**Consultation Response from KC,
Highways Development Management**

2023/91200 Land off, Briestfield Road, Briestfield, Dewsbury, WF12 0NR

**Discharge conditions 5, 6, 7 on previous permission 2021/93111 (APP/Z4718/W/22/3300539) for
erection of agricultural building**

Date Responded: 27-6-2023.

title access & internal service area details
number 21099D-05-P01
scale 1:200
size A3

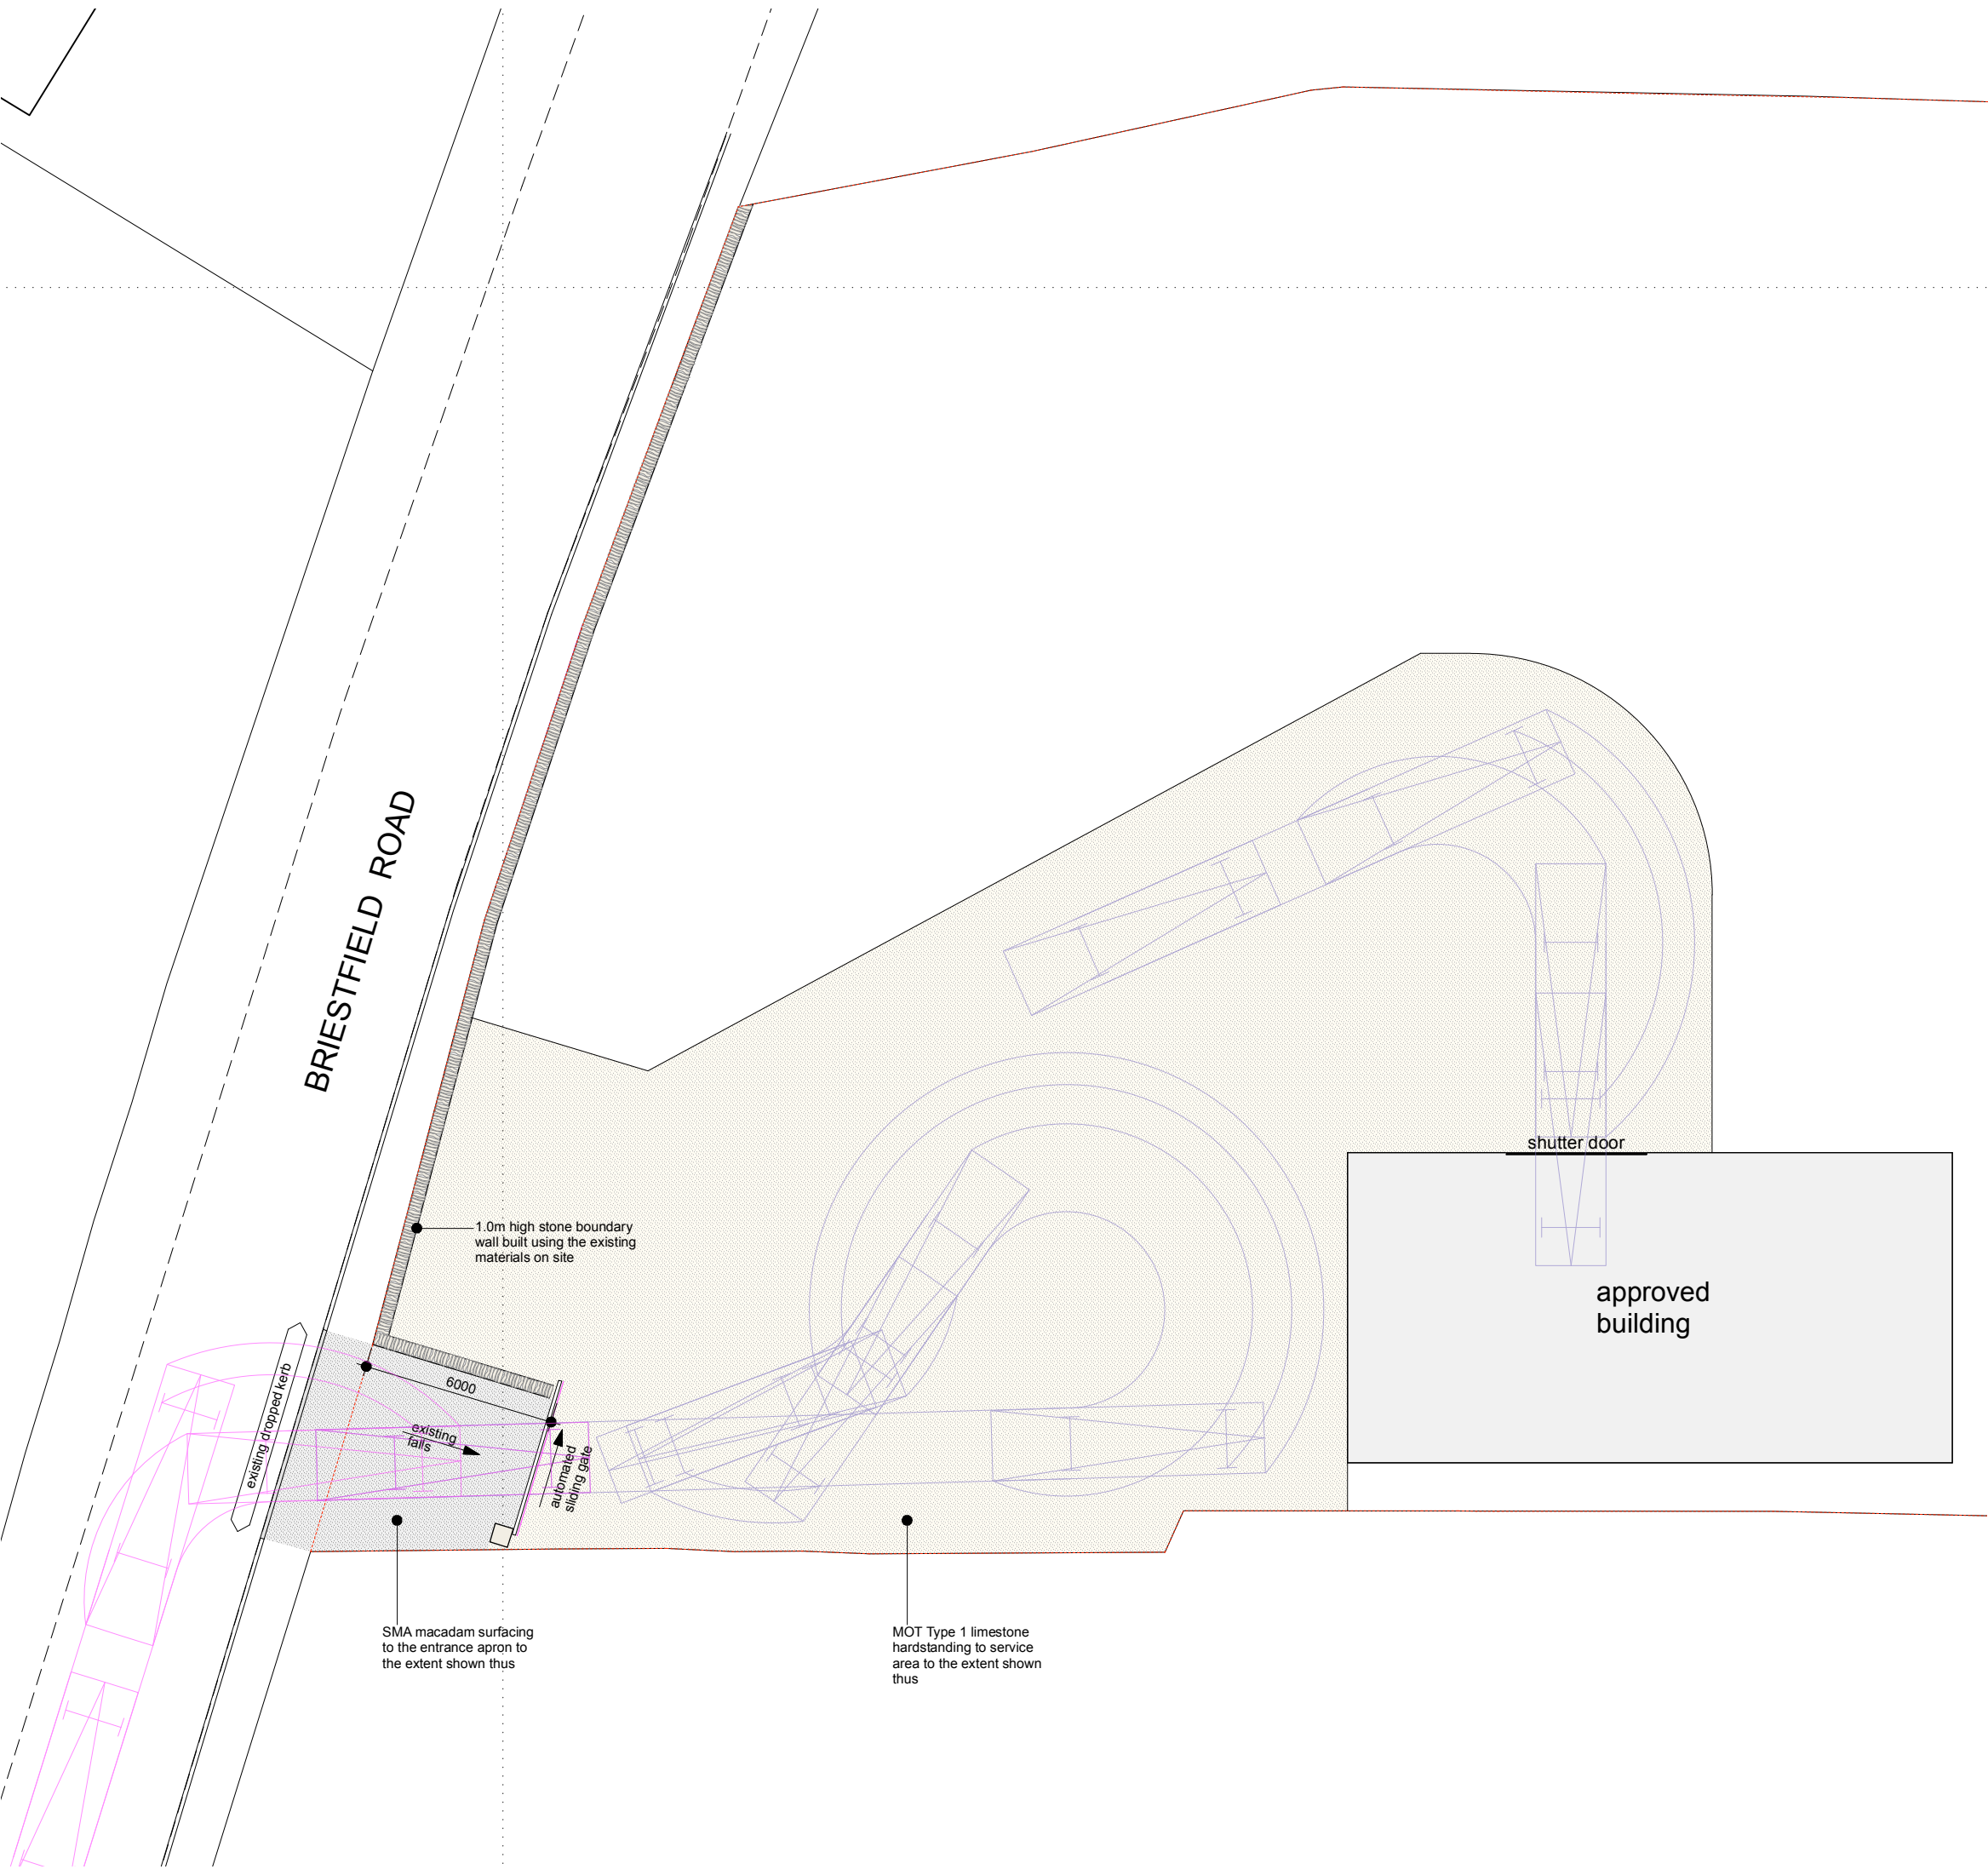
The applicants have provided plan numbers 21099D-05-P01 access & internal service area details and 21099D-05-P01 access & internal service area details 2.

The first plan shows the turning movements of an HGV within the site and the second an agricultural tractor.

The plans show the first 6m of the access tarmac surfaced and the boundary wall at a height of 1.0m to assist visibility onto Briestfield Road. PROW Dew/79/40 is also shown on the plans.

These proposals are considered acceptable and Highways Development Management have no objection to the discharge of this condition.

title access & internal service area details
number 21099D-05-P01
scale 1:200
size A3

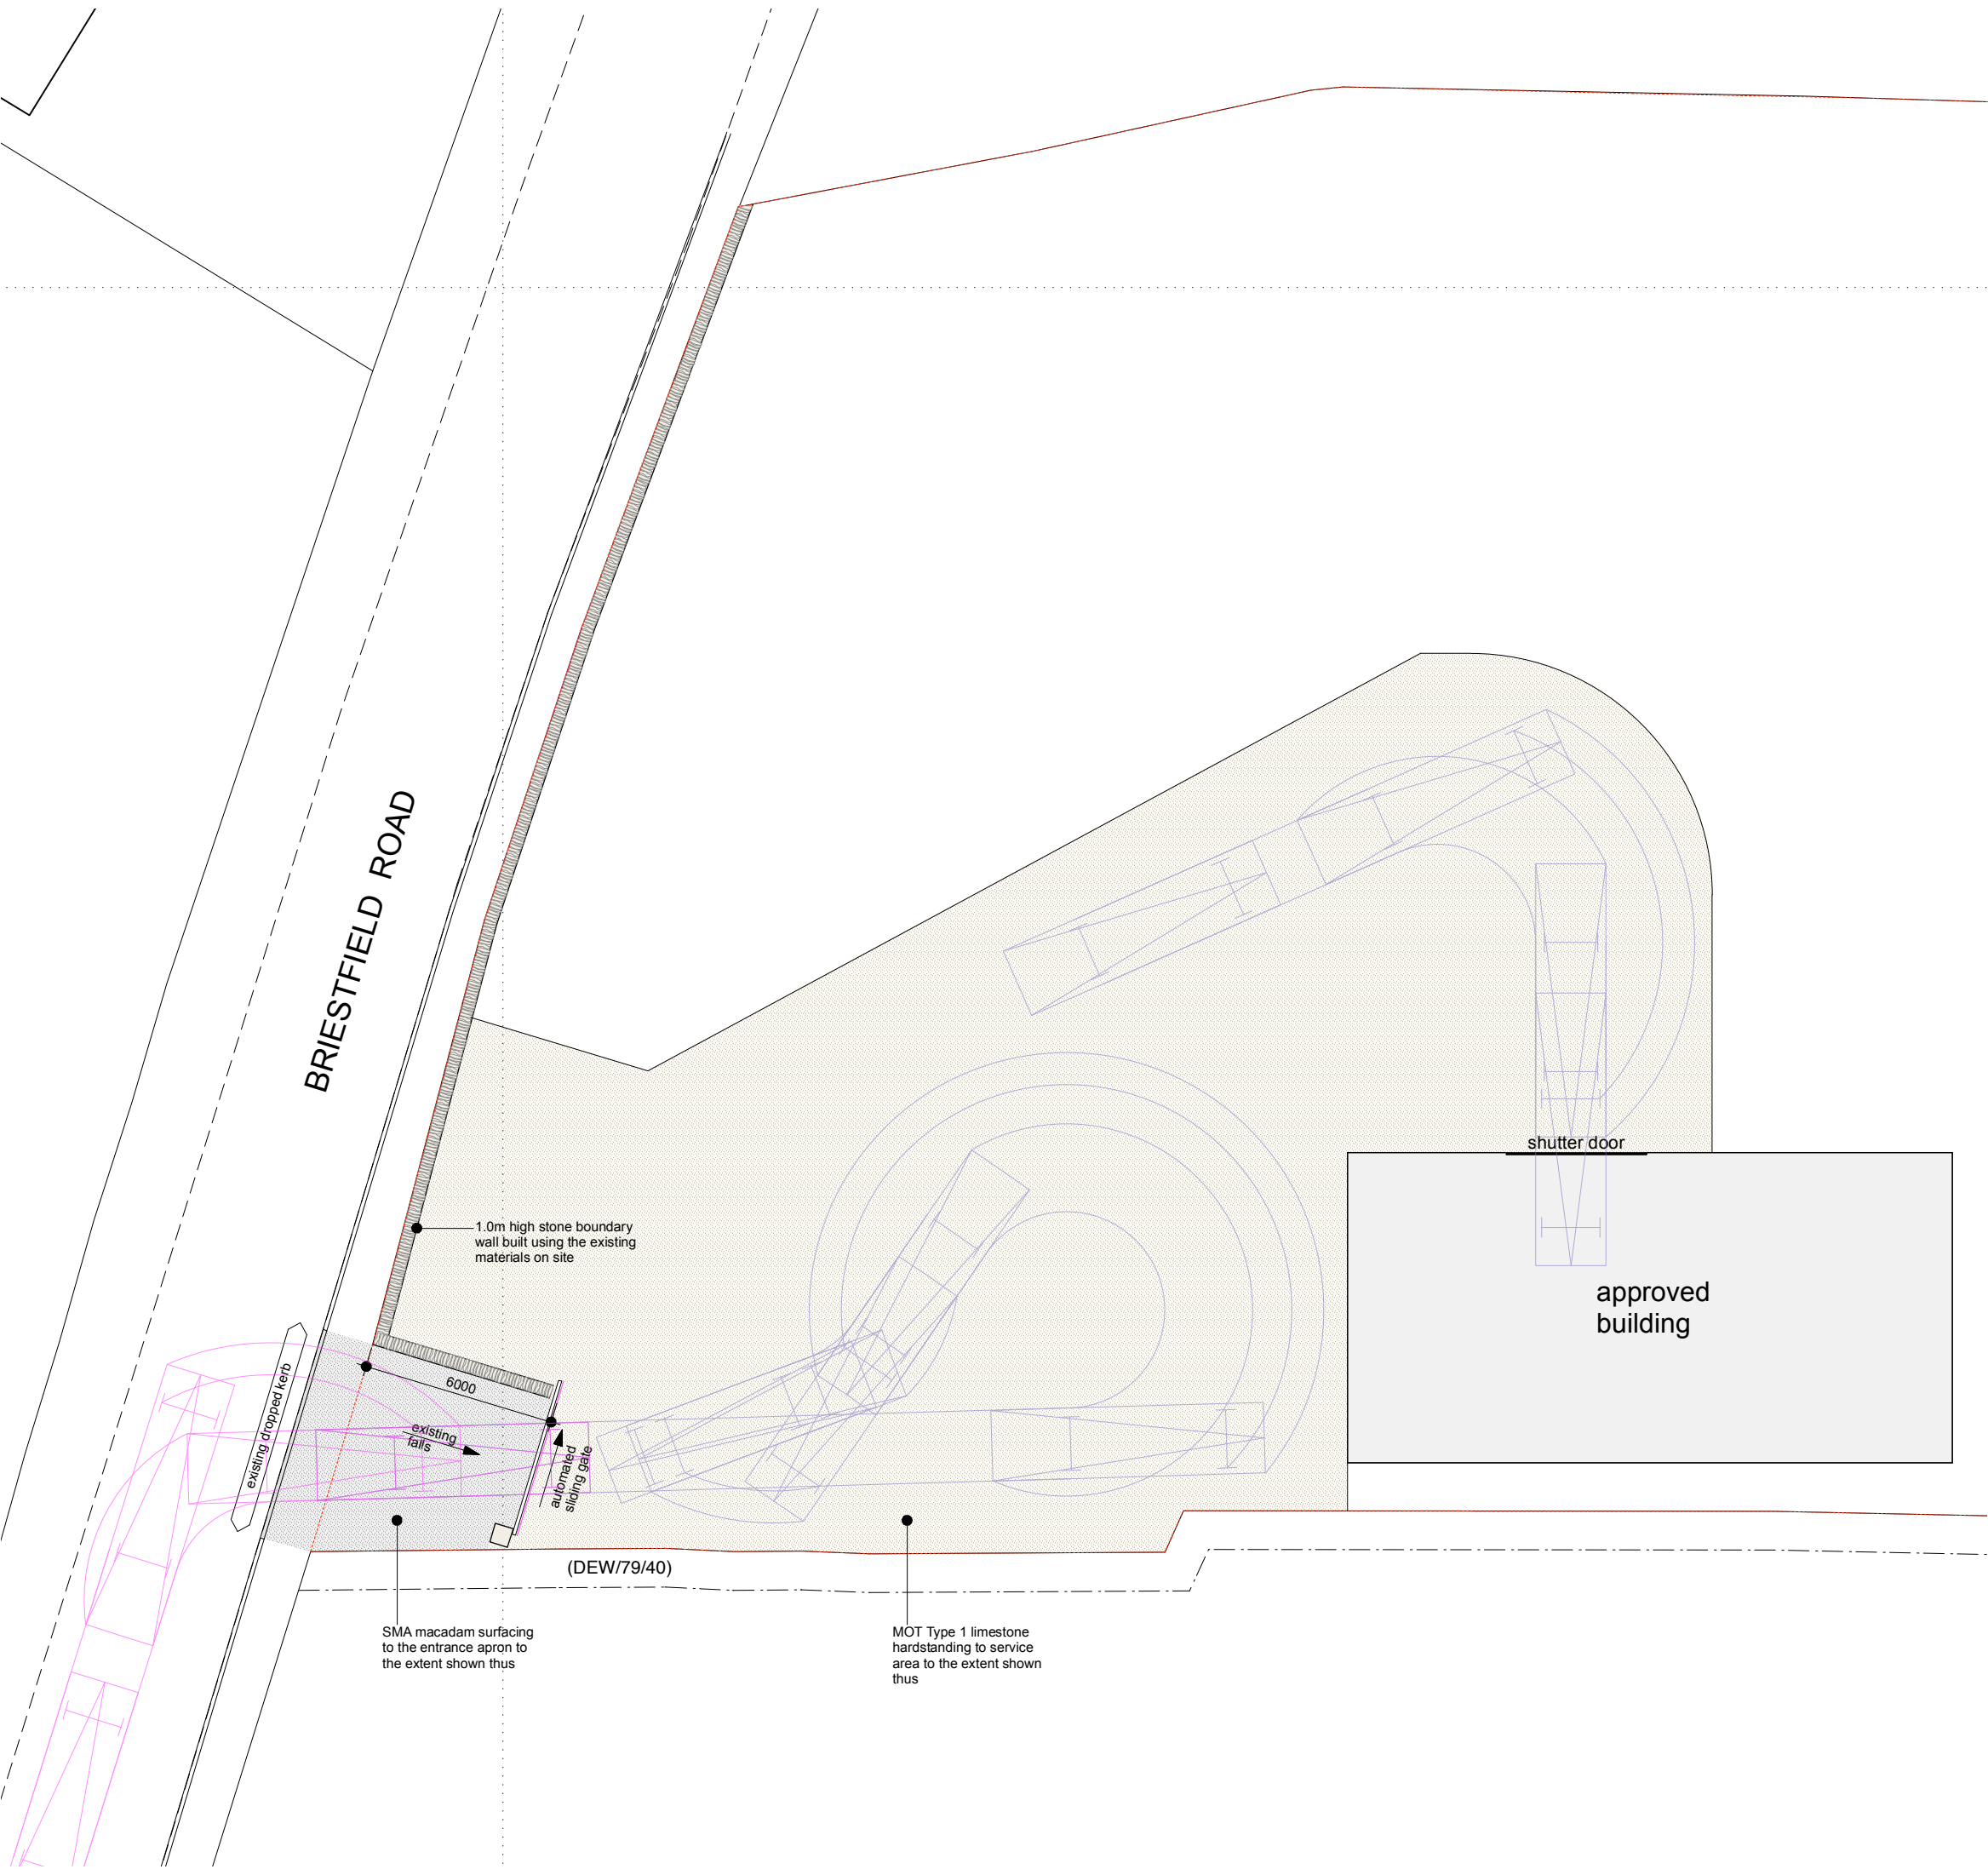
The applicants have confirmed in an e mail dated 27th June the largest vehicle that will regularly visit the site will be the tractor. The plan show that the tractor will have sufficient space to stand in front of the existing gates without obstructing the highway.
